Arthur Maxfield

10/31/2018

Planning Application Ref: R/197/18/HH – 1 Pigeonhouse  
Lane, Rustington

Drawing Title: PROPOSED ELEVATIONS

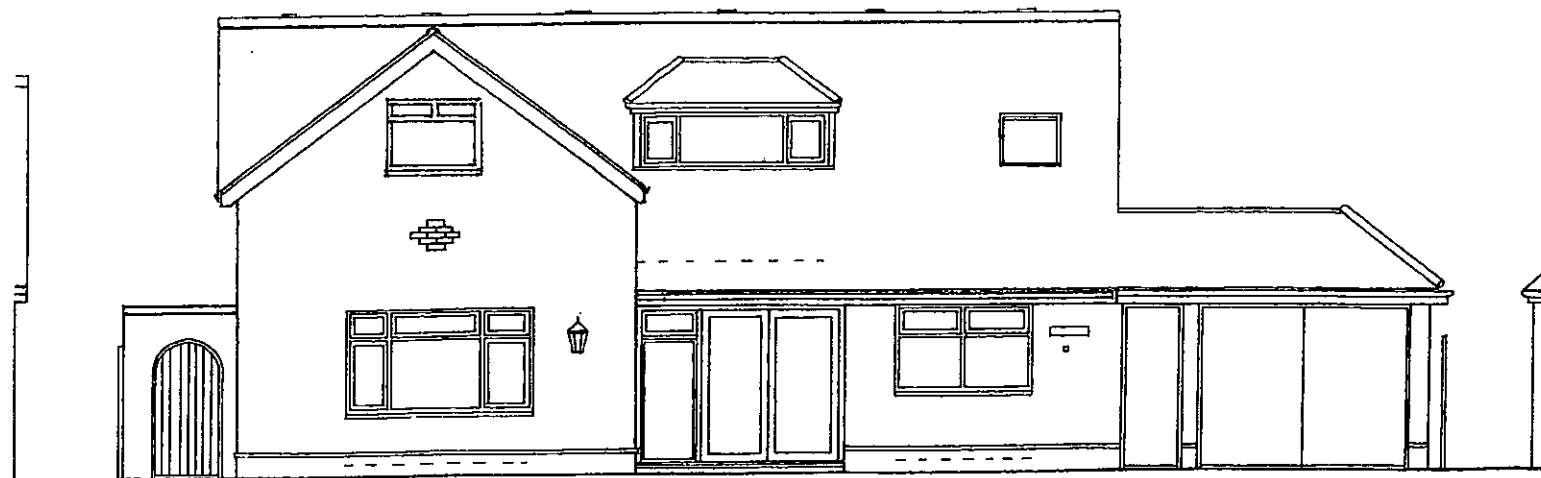
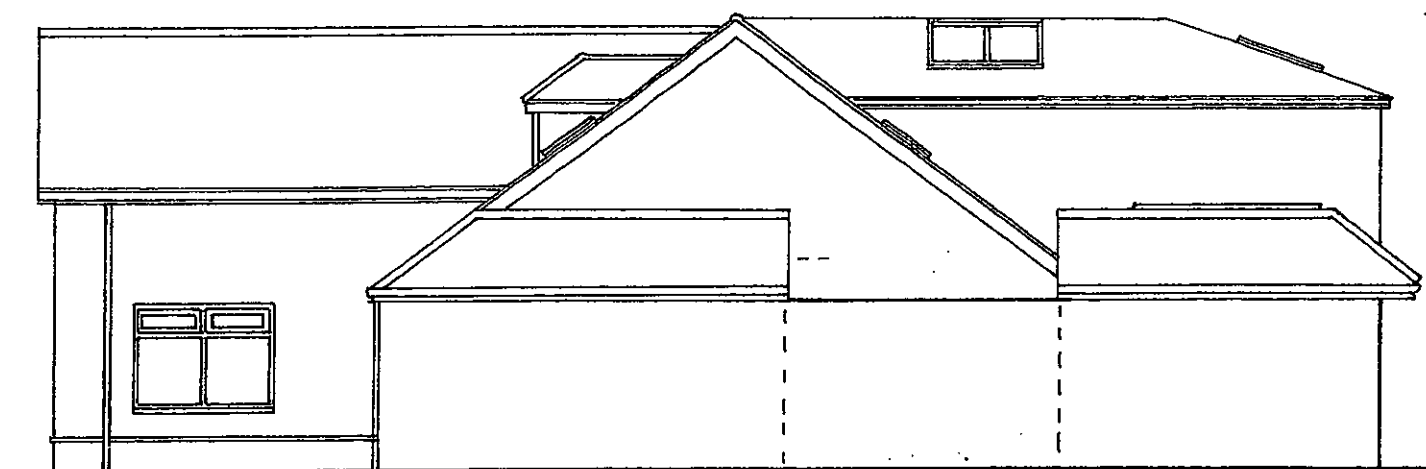
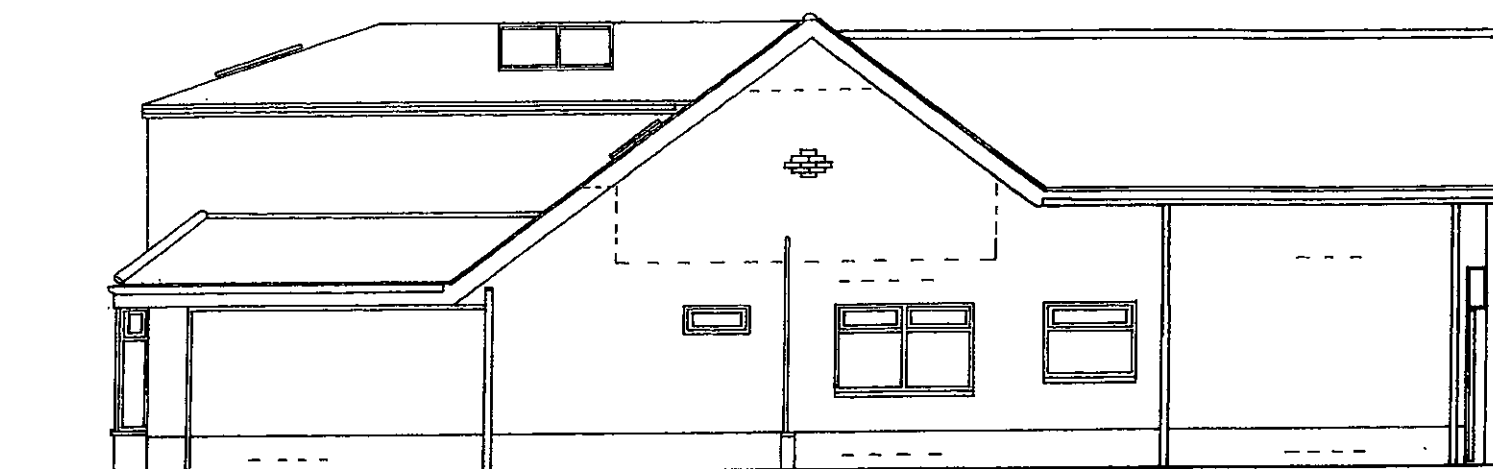
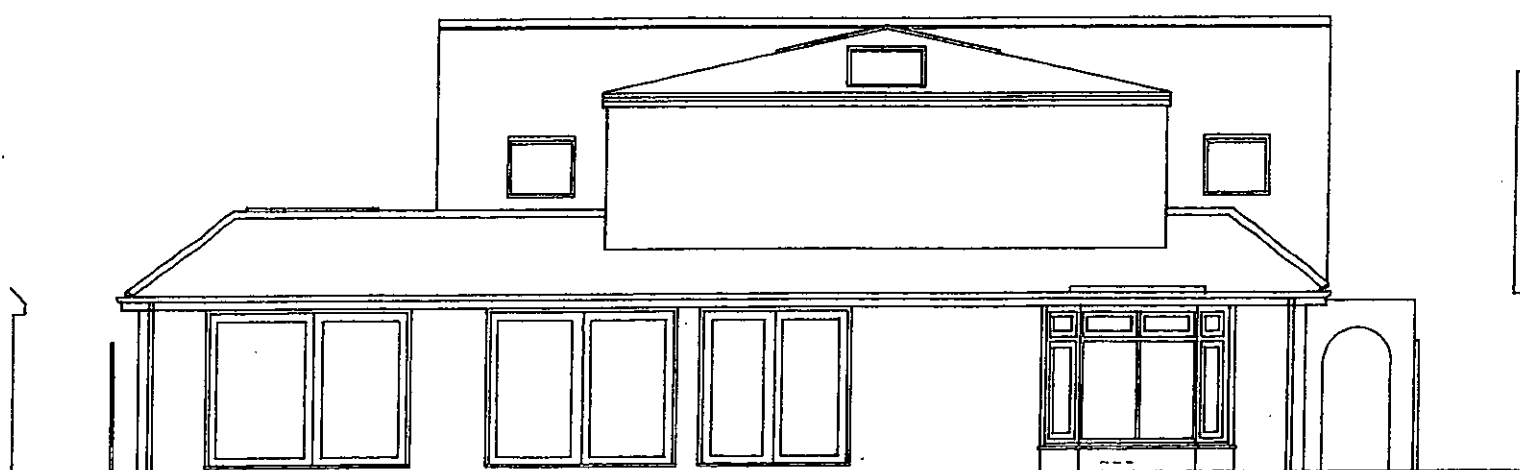
My property, 7 Cross Road, sits directly to the east of 1 Pigeonhouse Lane, and will be directly overlooked by the proposed development. The principal living areas of 7 Cross Road is a large kitchen family dining area that face due south and west and is accessed by 4 meter bi fold door / windows that are directly overlooked by this development. Given that 1 Pigeonhouse Lane and 7 Cross Road are sited in very close proximity. I strongly object to the above development project which essentially represents the addition of a full second storey to the existing bungalow. All of the proposed extension and elevation work to the rear is to take place very close to our Western boundary.

The proposed rear extension is a bulky and unattractive structure and is not integrated in appearance with the existing building. These plans would create an overbearing structure overlooking in to my dining room / family room and garden. The dominant effect of the structure would have a serious adverse impact.
